June 7, 2023

Re: Response to 4.25.23 Staff Comments on Alternative Landscape Plan for Ventura Self-Storage

TREE PLANTING DETAIL

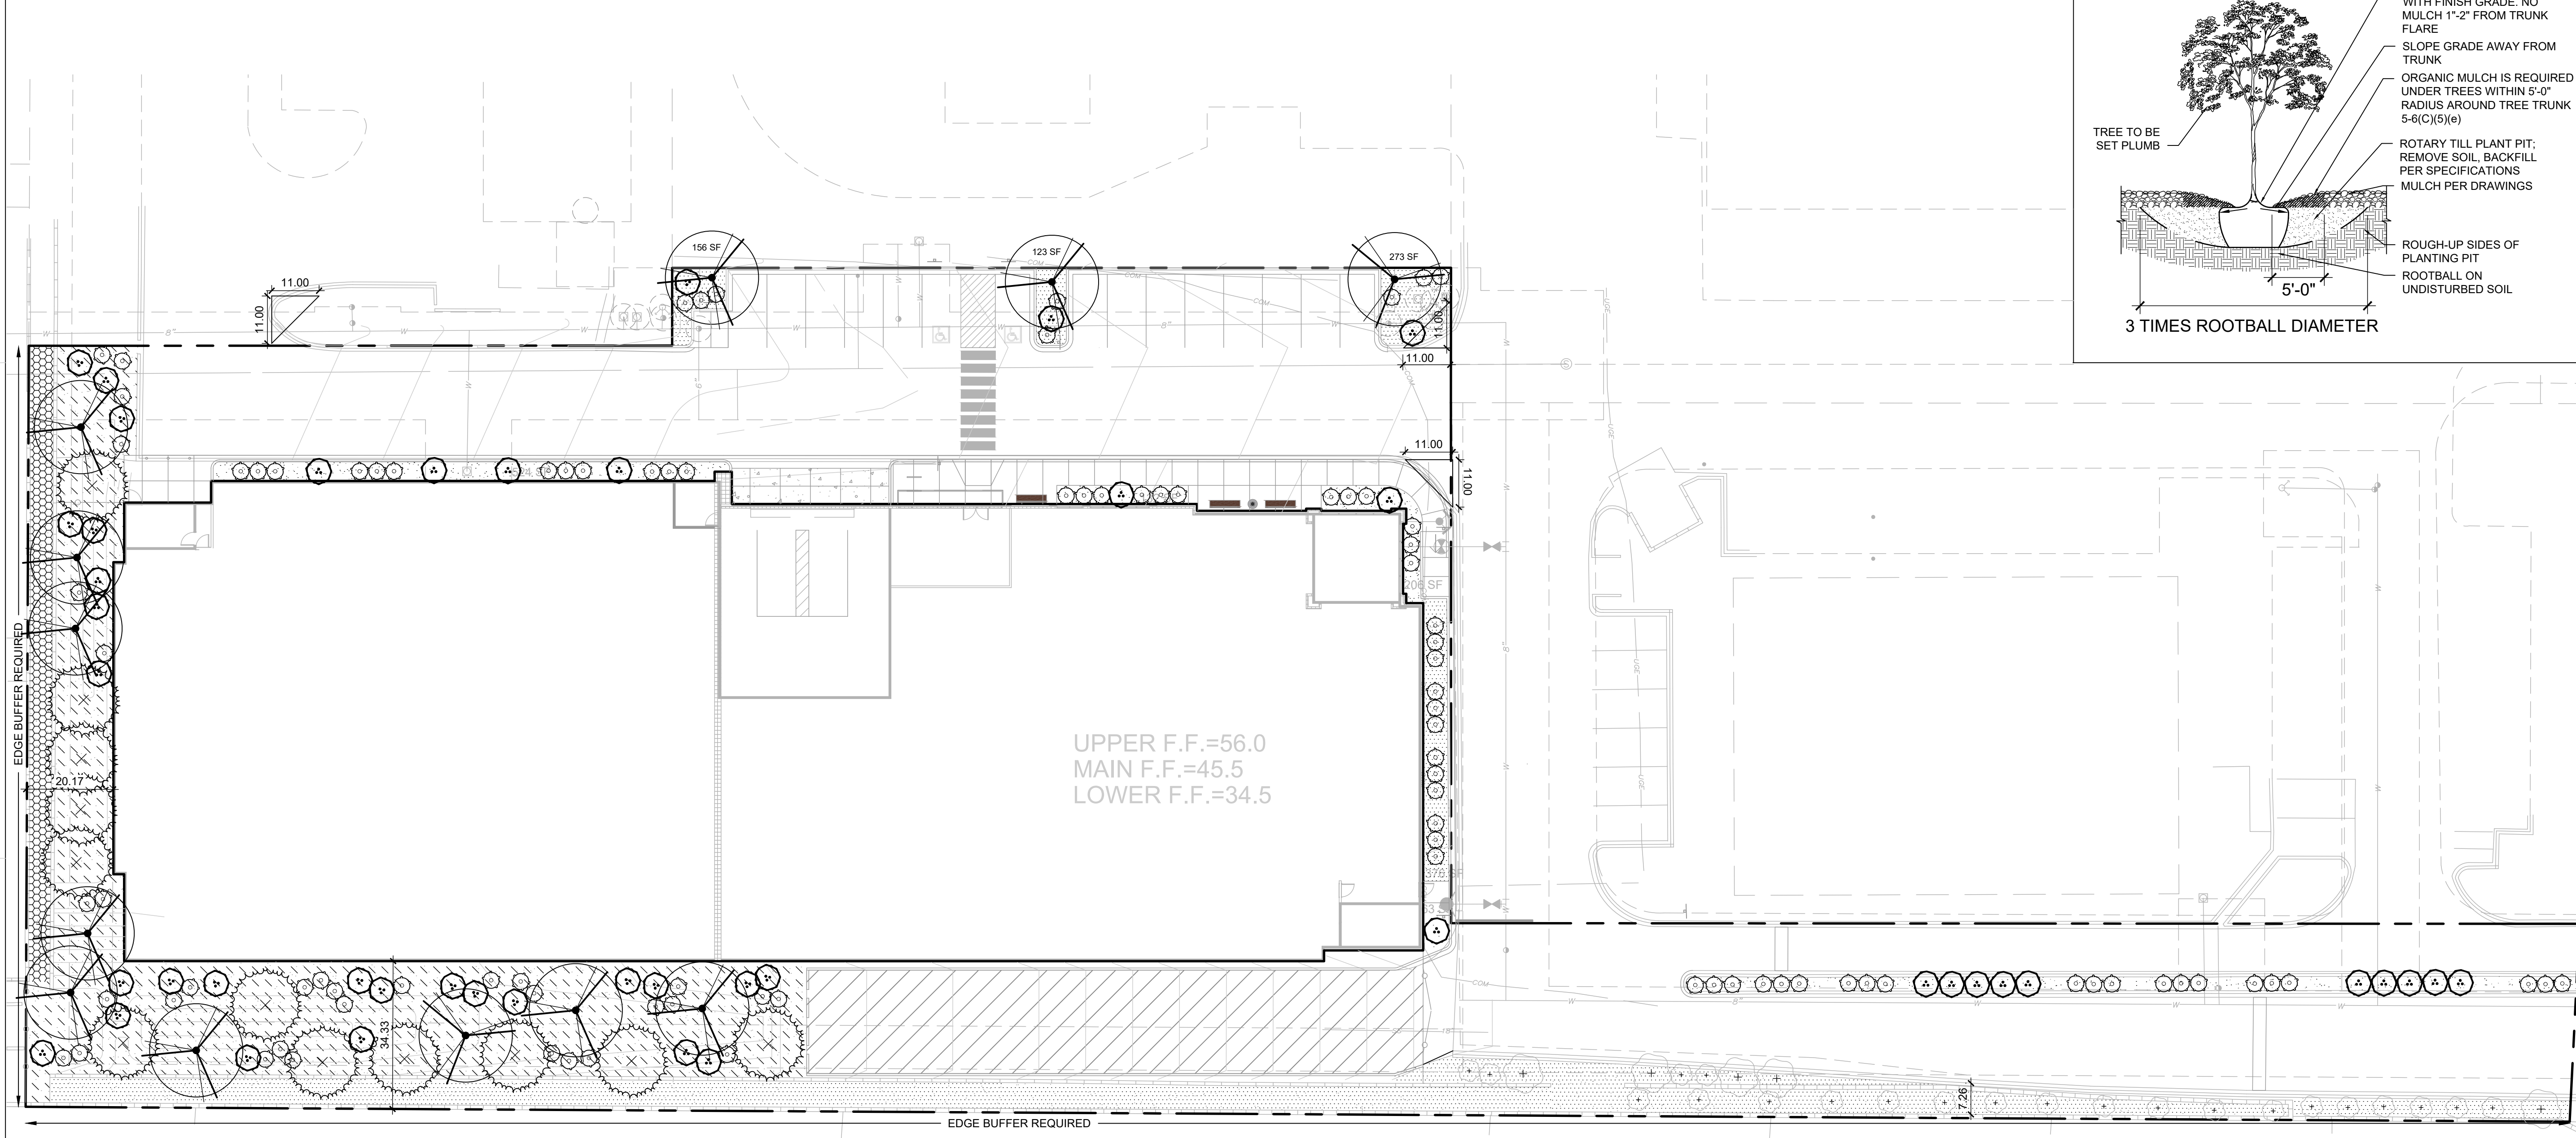
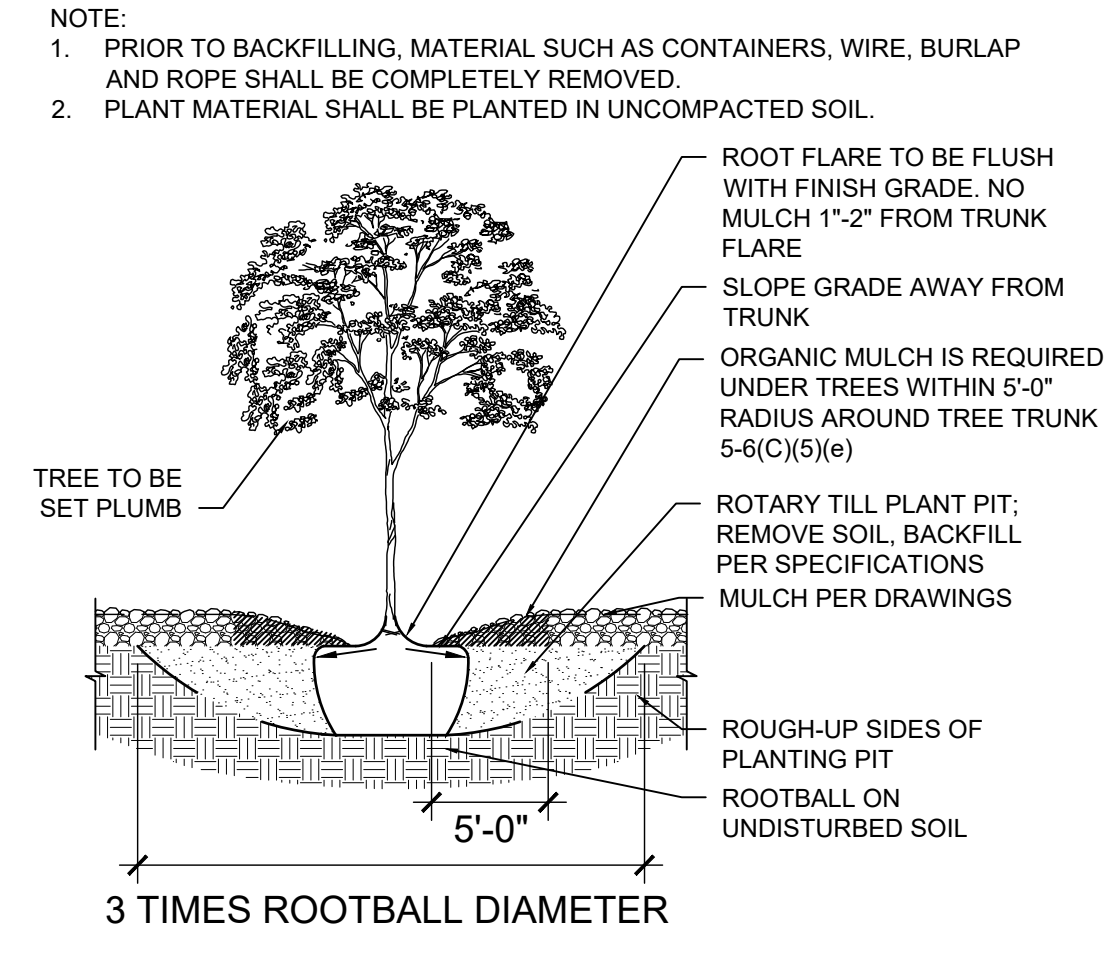
Per 5-6(C)(5)(e) Organic mulch is required as ground cover under trees within a 5- foot radius around the tree trunk, but not directly against the trunk. In these areas, weed barrier fabric is prohibited. Please remove the weed barrier from the subject area. See the marked-up illustration below.

Figure A-1: Tree Planting Detail illustrated on the proposed landscape plan has been corrected to remove the weed barrier.

Per 5-6(C)(7)(a) Vegetation required by this Section 14-16-5-6 shall be located at least 3 feet in any direction from any fire hydrants, valve vaults, hose bibs, manholes, hydrants, and fire department connections. Articulate how the proposed landscape plan complies with this code. Wherever the utilities above exist on the Landscape Plan, please show a 3-foot radius circle to demonstrate how this code is being complied with.

Per 5-6(C)(5)(f) All landscaped areas shall be protected from vehicular encroachment by curbs or wheel stops located 2 feet outside the landscaped area, with openings to accommodate surface collection of stormwater runoff in vegetated swales and stormwater infiltration areas. Does this apply to the fire access lane as well? Please confirm that the lines pointed at below are demonstrating a curb. If so, please make proper adjustments to move the vegetation at least 2 feet away from the curb.

The landscape sheet has been revised to include a dashed 3' radius around any hydrants, valve vaults, hose bibs, manholes, hydrants, and fire department connections and plants that were intersected were moved. All vegetation indicated within the landscape plan are now located a minimum of 3 feet from fire hydrants, valve vaults, hose bibs, manholes, hydrants, and fire department connections.

Based on the last round of staff comments received, our interpretation was that staff wanted this requirement to be applied to the fire lane so curbs were added to the fire lane.

The landscape plan was revised so that all vegetation was a minimum of 2' away from the curb.
